## PLANNING CONSULTATION RESPONSE

<b>Application No</b>	2025/0508
<b>Proposal</b>	Erection of stables
<b>Address</b>	Land rear of 8 Cliff Lane, Brierley, Barnsley, S72 9HR
<b>Date of Consultation Reply</b>	16/12/2025
<b>Consultee</b>	Katie Lawrence, Planning Ecologist

SITE LOCATION PLAN
AREA 5 HA
SCALE: 1:1250 on A4
CENTRE COORDINATES: 440674 , 411047

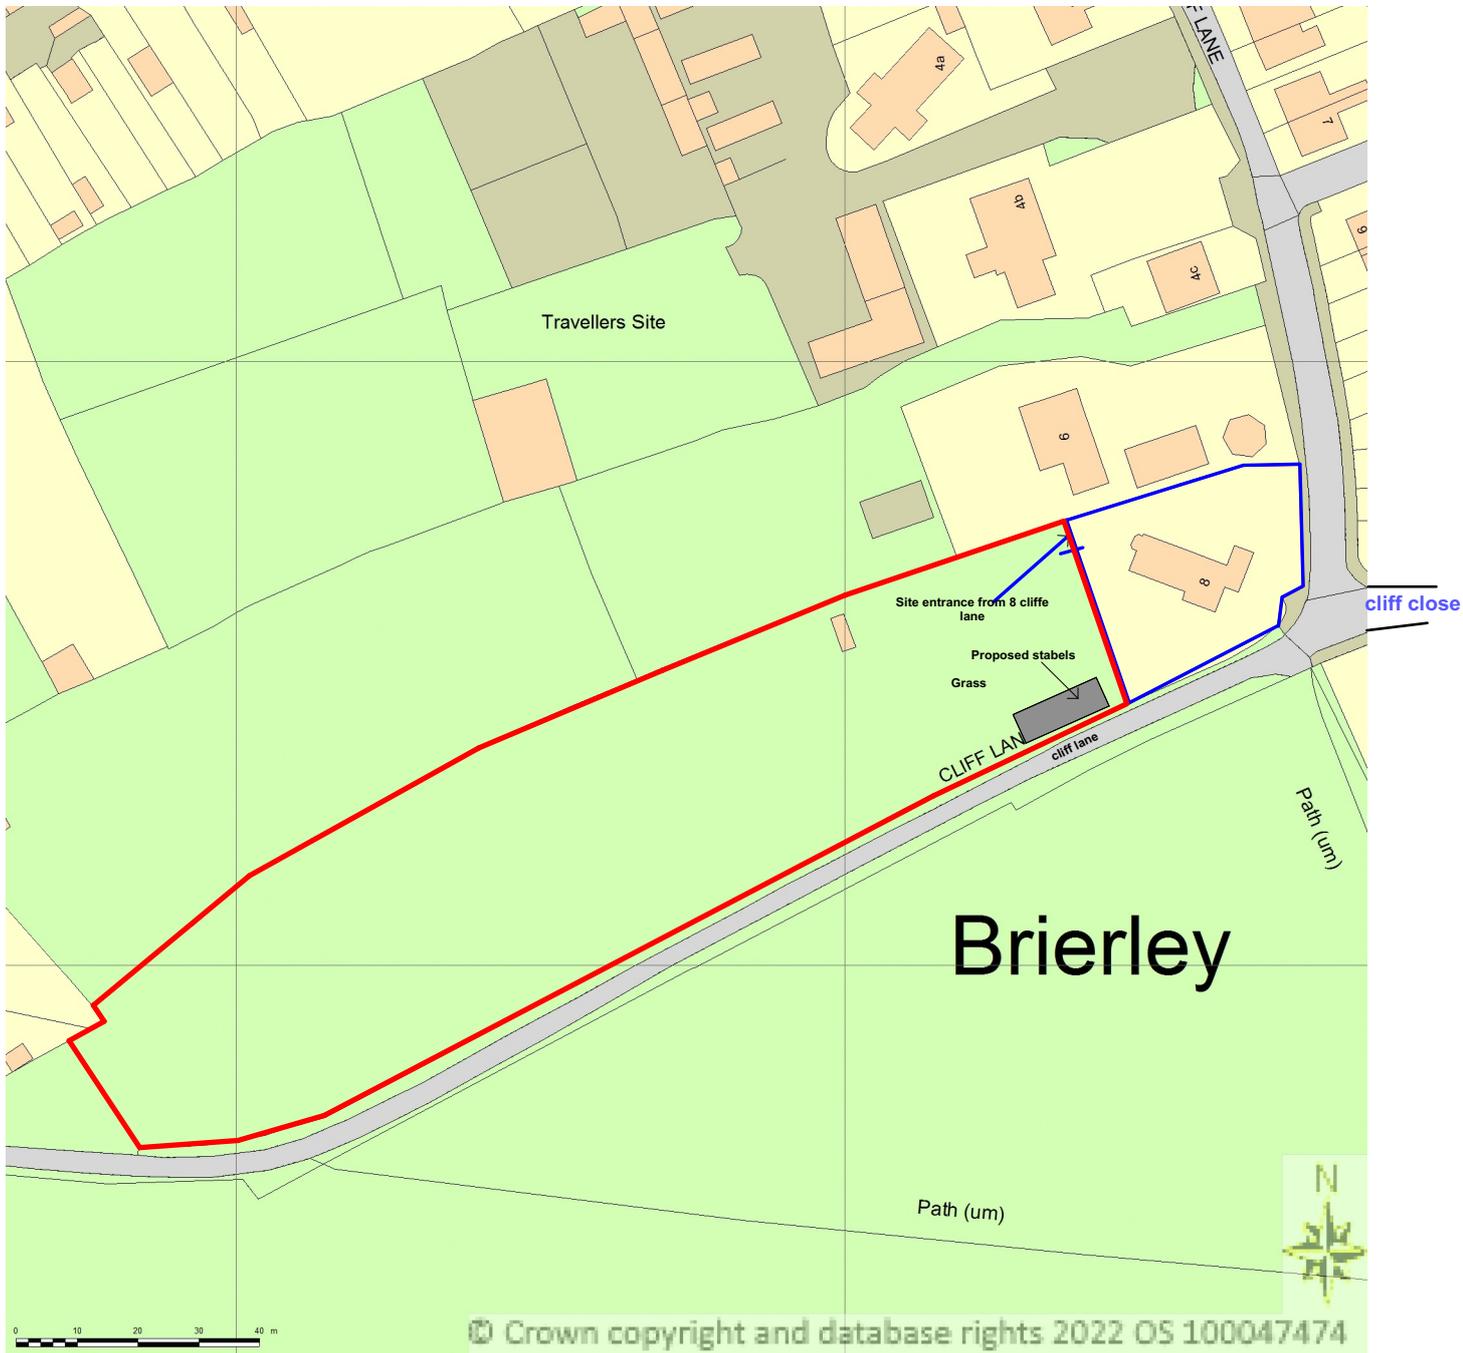
Thank you for consulting me regarding this application. Following my previous consultation response the site plan has been amended to include the area previously within the blue line boundary. This now means habitat enhancement proposals are located on-site rather than off-site, negating the requirement for this to be secured by a Section 106; however, as the applicant is still proposing other neutral grassland (a significant enhancement) a Habitat Management and Monitoring Plan (HMMP) will be required, and we will seek a monitoring fee for review of monitoring reports over the 30-year management period. Due to the small size of the proposed habitat enhancement areas, the LPA would seek a monitoring fee of £5000. The fee would be secured as part of a Section 106 agreement. The applicant should advise whether they are happy to proceed on this basis as this would need to be arranged prior to planning permission being granted.
